WESTMEAD CATHOLIC COMMUNITY EDUCATION CAMPUS APPENDIX A - RESPONSE TO SUBMISSIONS AND REQUEST FOR ADDITIONAL INFORMATION AND CLARIFICATIONS

scale: As ind1:500

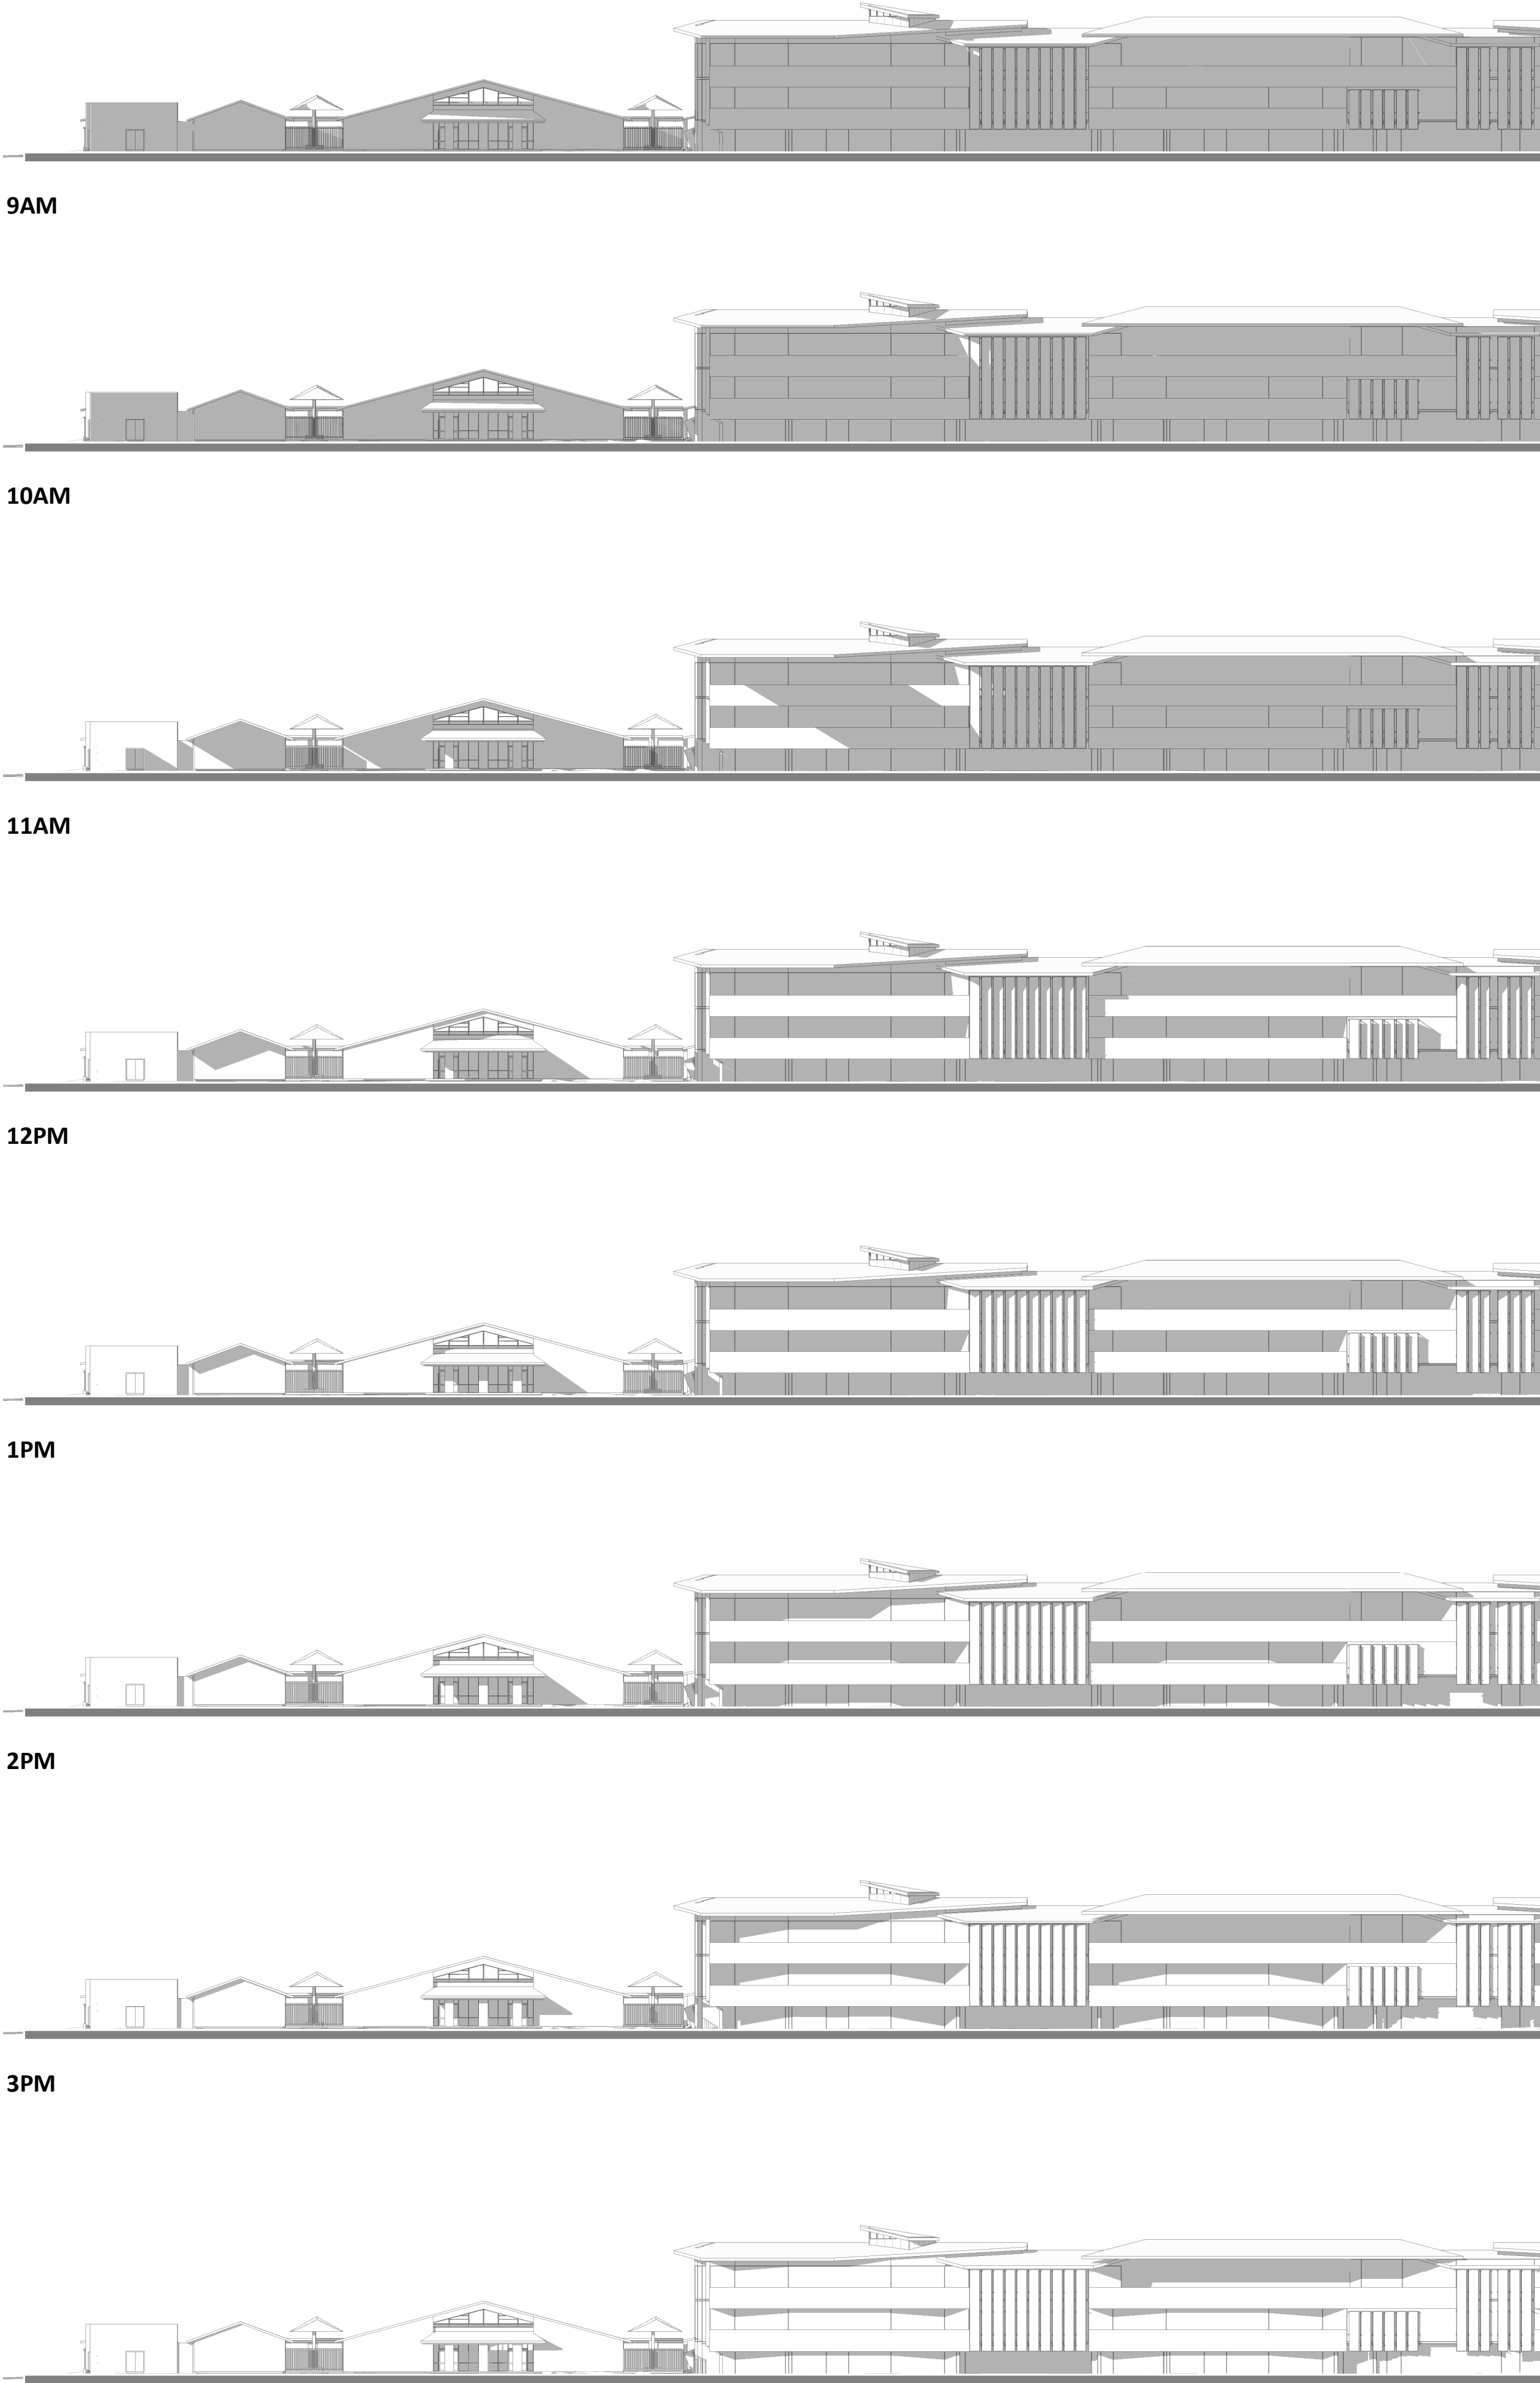
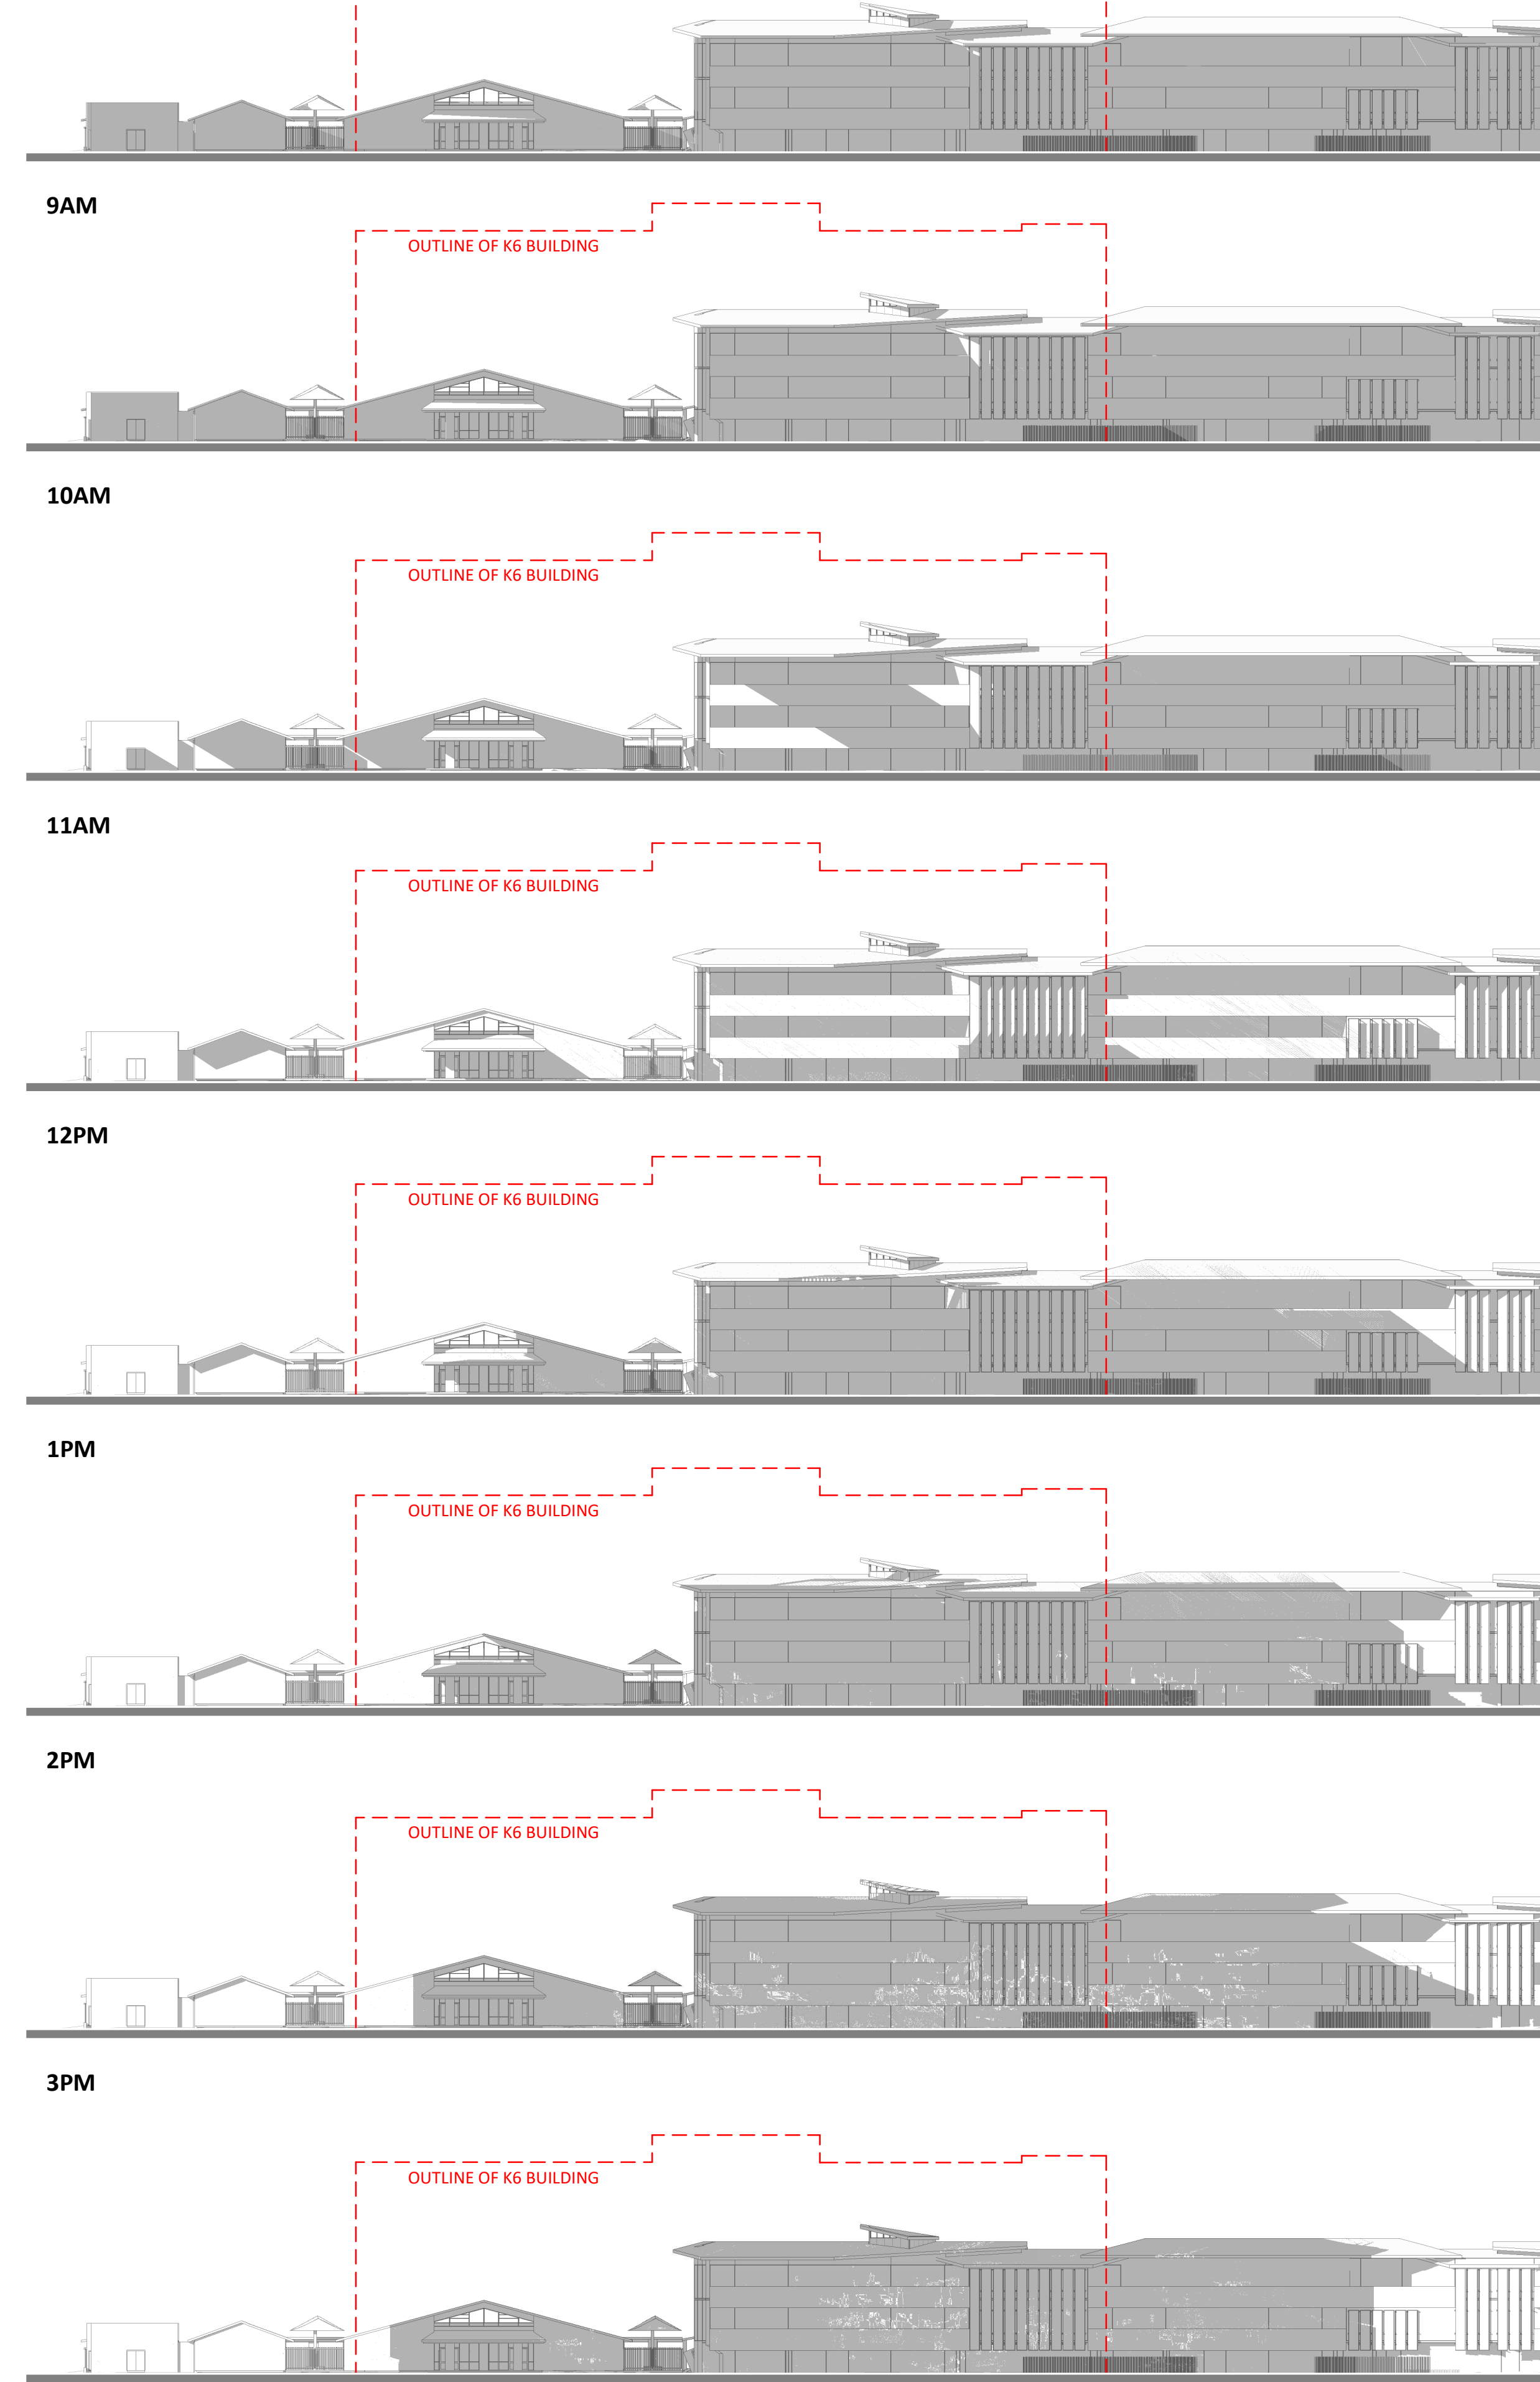
27			<p><u>Shadow diagrams</u> Hourly elevational shadow diagrams are to be provided for the proposed development during the winter solstice to assess the impacts of the primary school building on the façade of the childcare centre / administrative building.</p>	<p>Additional Shadow Diagrams have been prepared and are provided at Appendix B.</p> <p>The diagrams show that on the winter solstice, shadow impacts will be unchanged in the morning period. After midday, the proposed building will cause additional overshadowing of the CELC building.</p>

Item No	Name	Type	Issue	Response
				On the equinox, shadow impacts are largely unchanged until approximately 1pm. After 1pm, the proposed building will cause additional overshadowing of the CELC building. Whilst there be some additional overshadowing, this will not have a significant impact on the use of the existing building.
28			<u>Plans</u> The Submitted architectural plans do not clearly differentiate which parts of the ground floor of the primary school is covered and are within the building envelope. Therefore, revised architectural plans are to be submitted to clarify this.	This detail is shown on the revised Architectural Drawings at Appendix B .
29			The revised plans must include the outline of the roof over each floor to identify the covered open space area on each level.	This detail is shown on the revised Architectural Drawings at Appendix B .
30			<u>Photomontage</u> Photomontage of the proposed buildings in relation to the existing buildings on site, (preferably from various angles to cover all the buildings on site) should be submitted so that the relationship of the proposed development and the existing developments on the site can be assessed in detail.	Additional photomontages have been provided at Appendix I .
